Rezoning Transportation Analysis
Petition Number: Insert Zoning Petition #2021-042
General Location Identifier: 14125107 & 14125108

Revision Log:	Date	Description
	04-29-2021	First Review (KP)
	05-27-2021	Second Review (KP)
	06-30-2021	Third Review (KP)

Transportation Summary

RZP-2021-042 Conditional Rezoning Site Plan

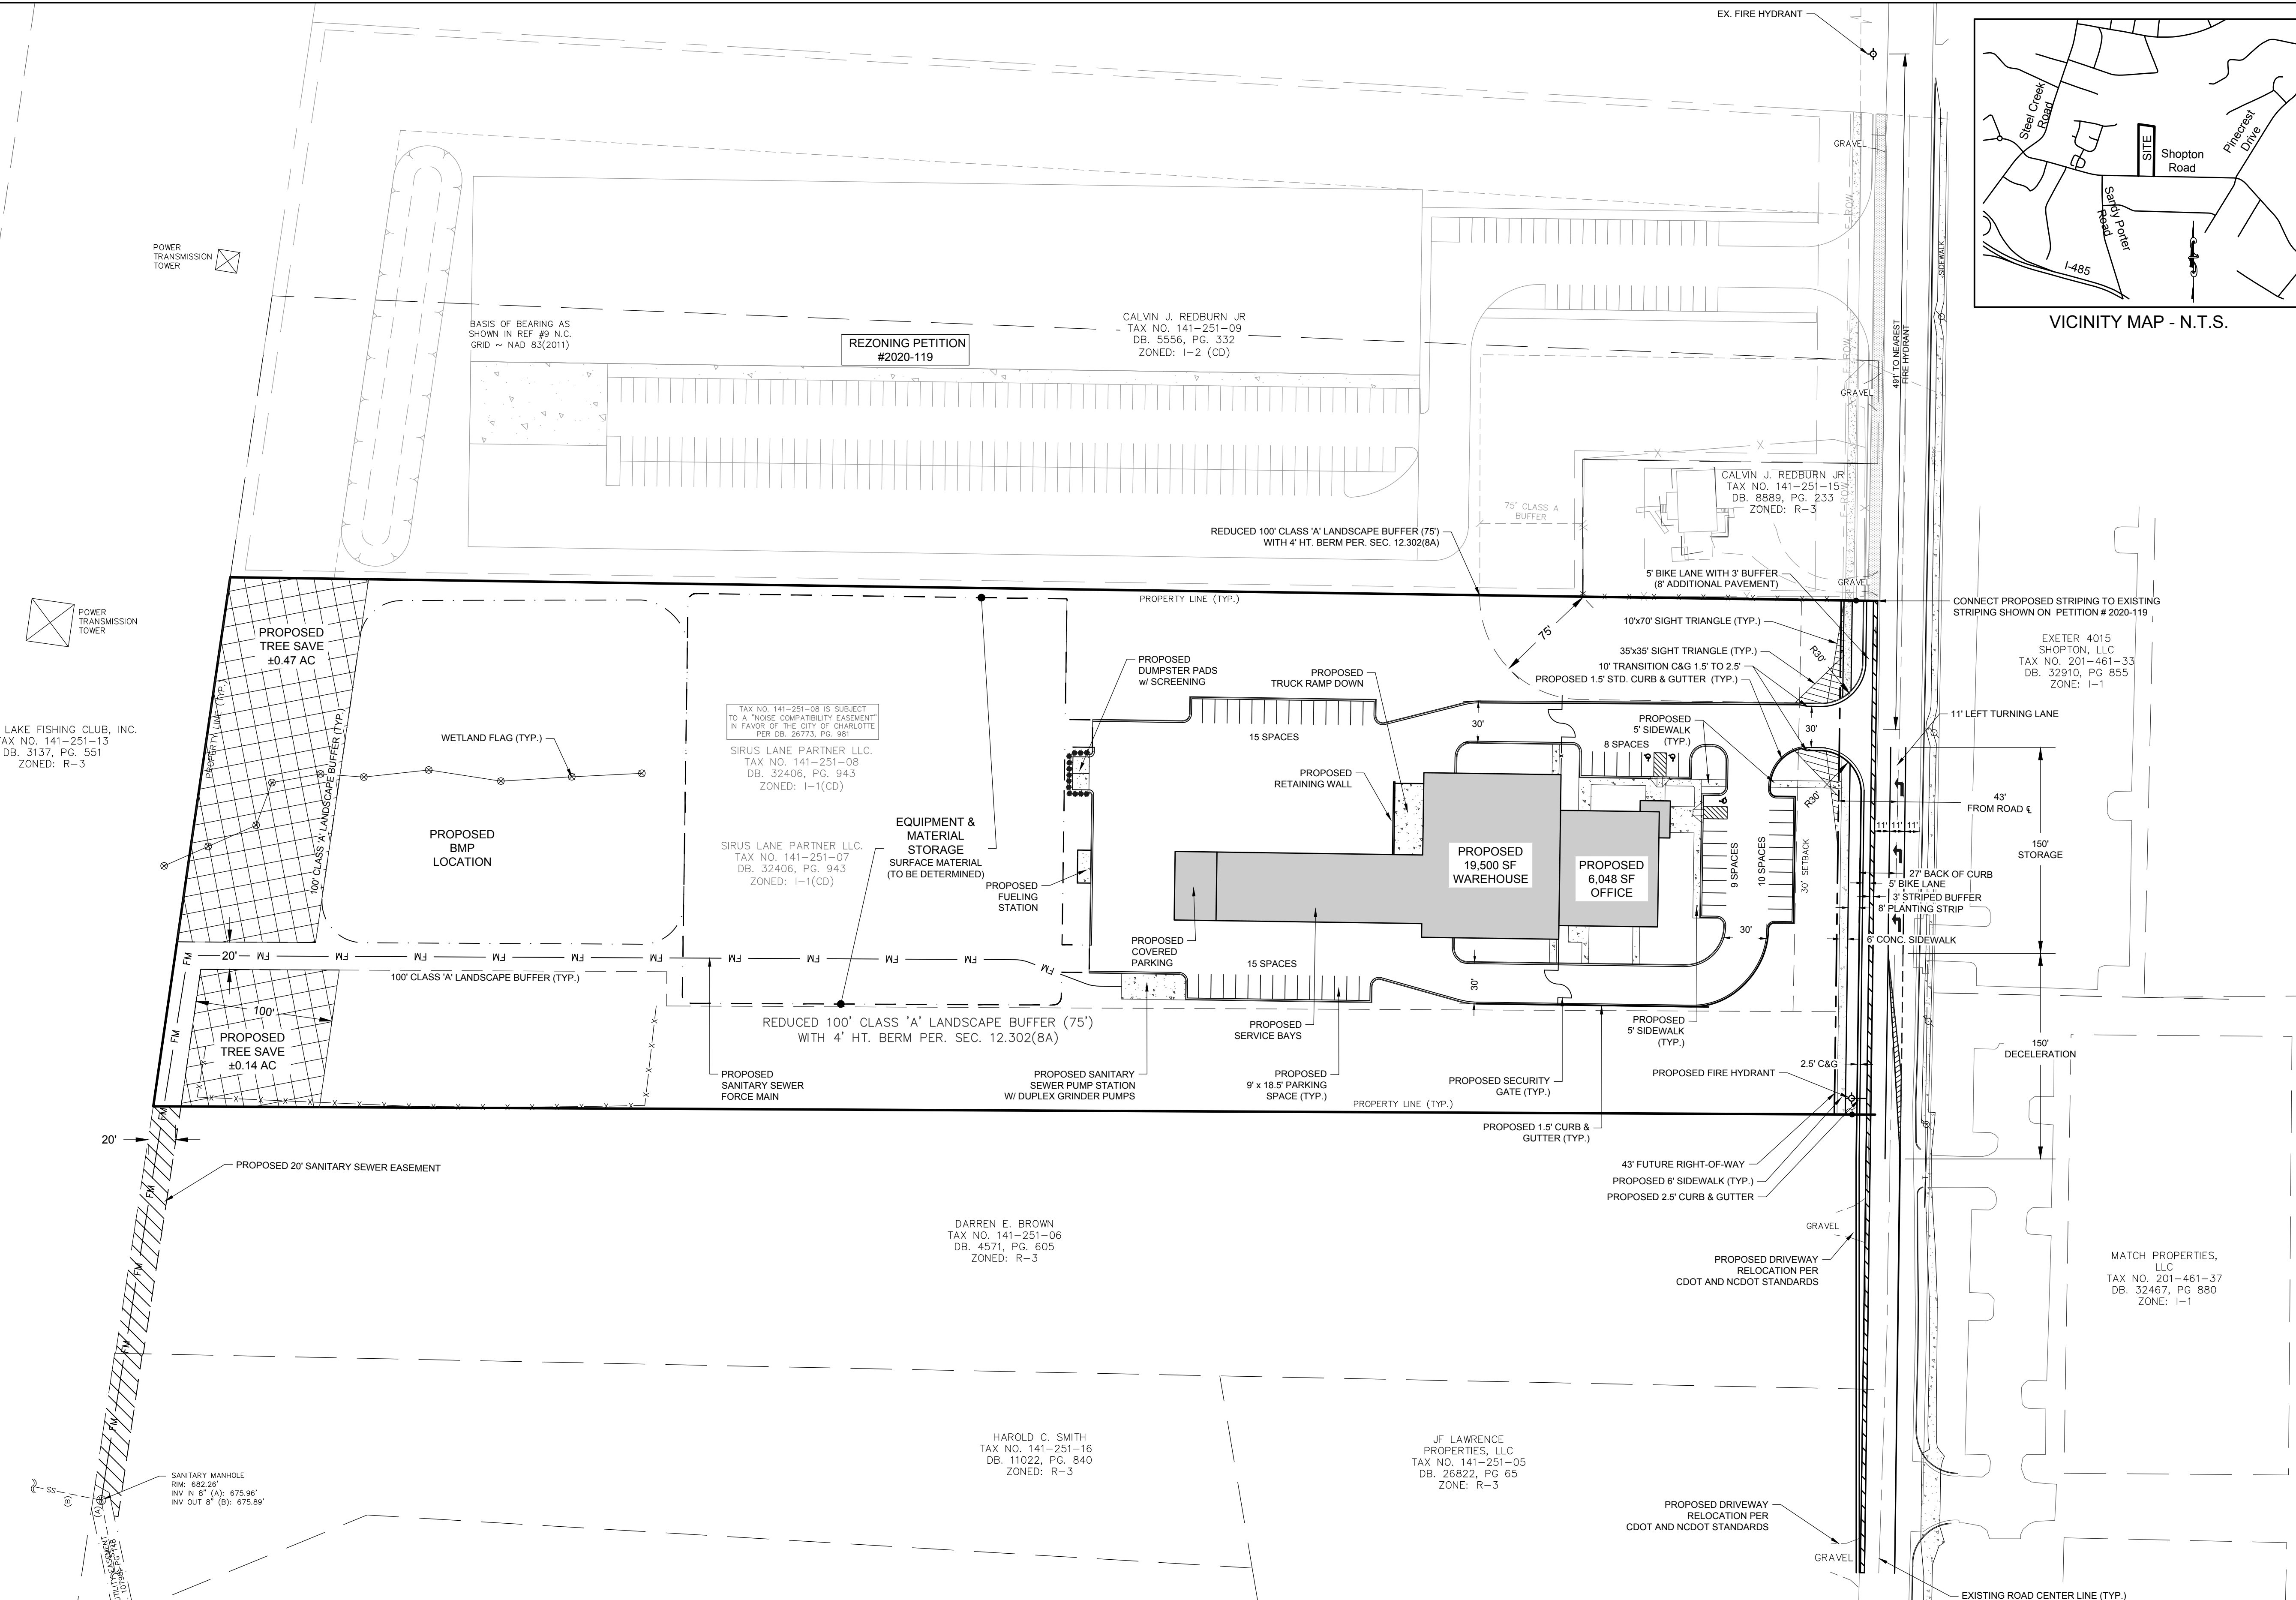
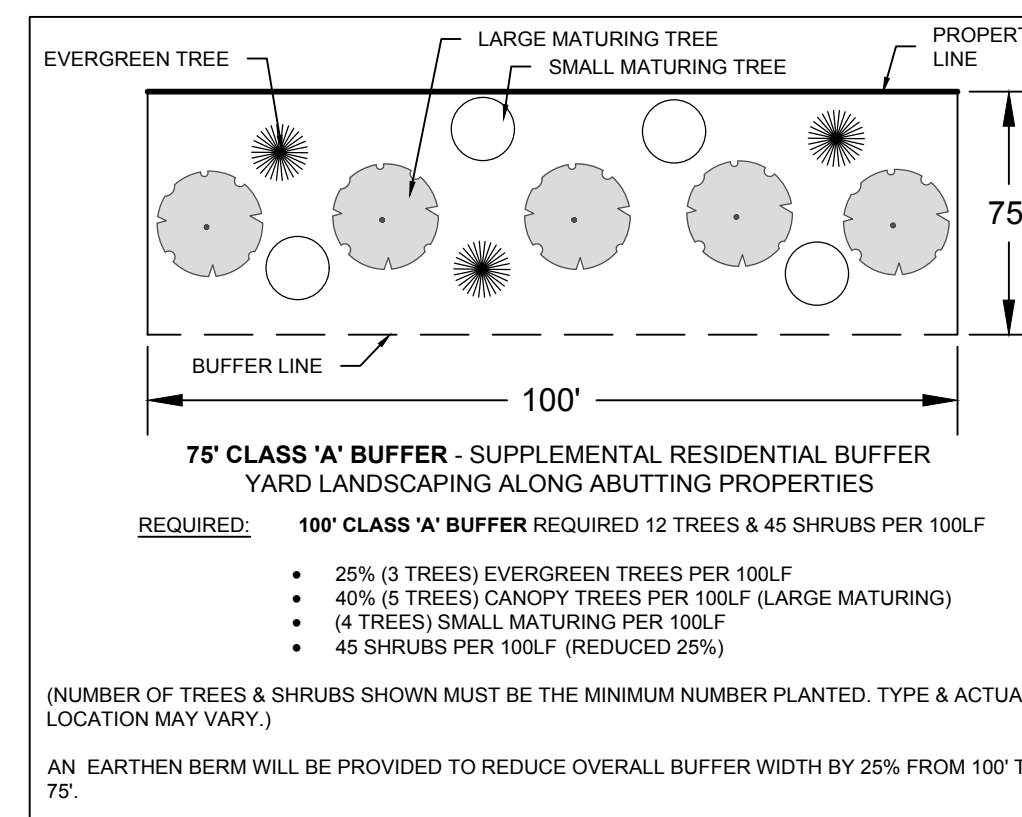
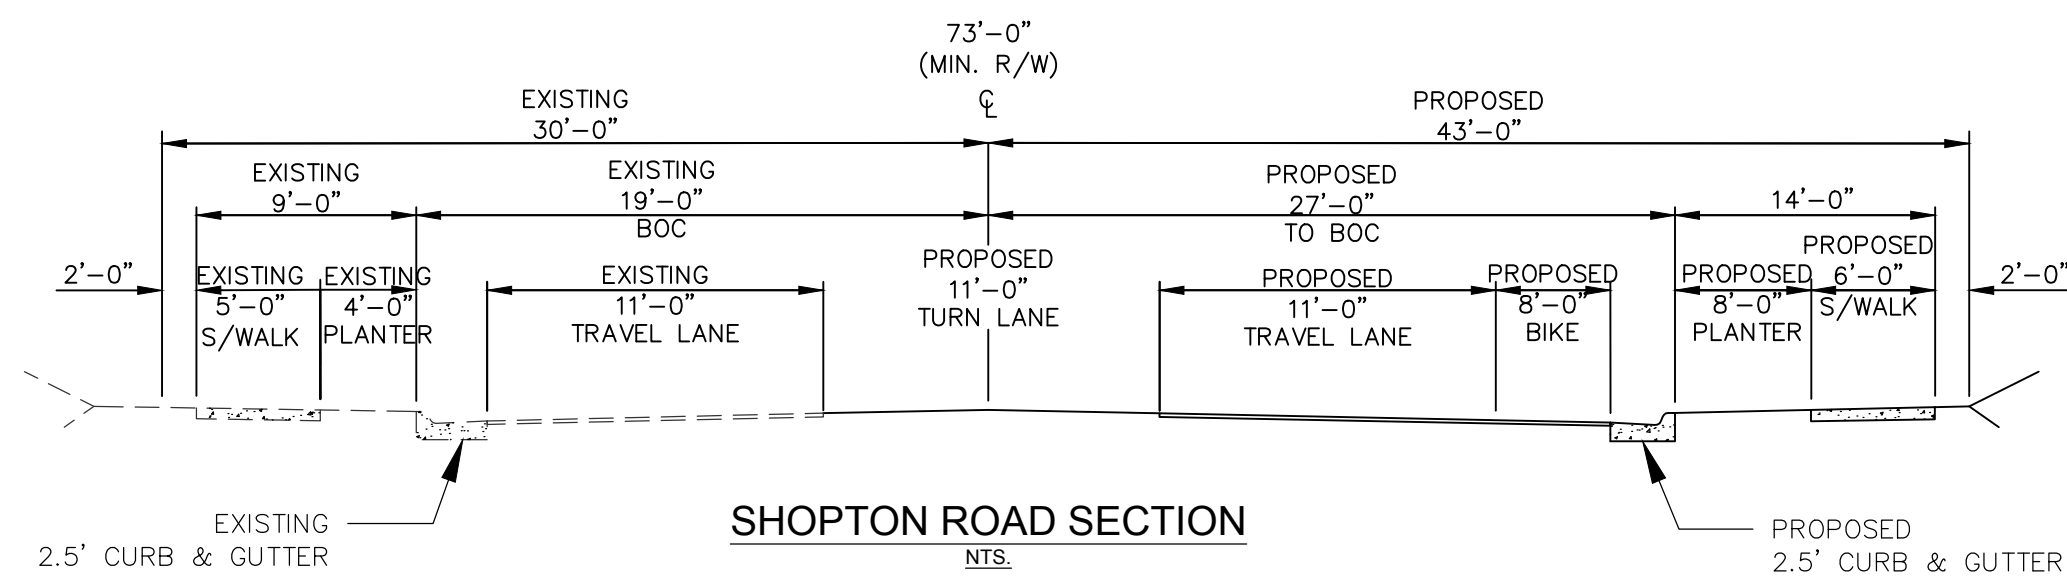
11. ~~**New Comments from 05-18-2021 Site Plan: Revise conditional notes III.5 & III.6.**~~
(as reasonably determined by NCDOT) are not completed at the time that the Petitioner seeks to obtain a certificate of occupancy for building(s) on the Site in connection with related development phasing described above, then NCDOT will instruct applicable authorities to allow the issuance of certificates of occupancy for **All right-of-way** buildings, and in such event the Petitioner may be asked to post a letter of credit or a bond for any improvements not in place at the time such a certificate of occupancy **will occur** to secure completion of the applicable improvements.
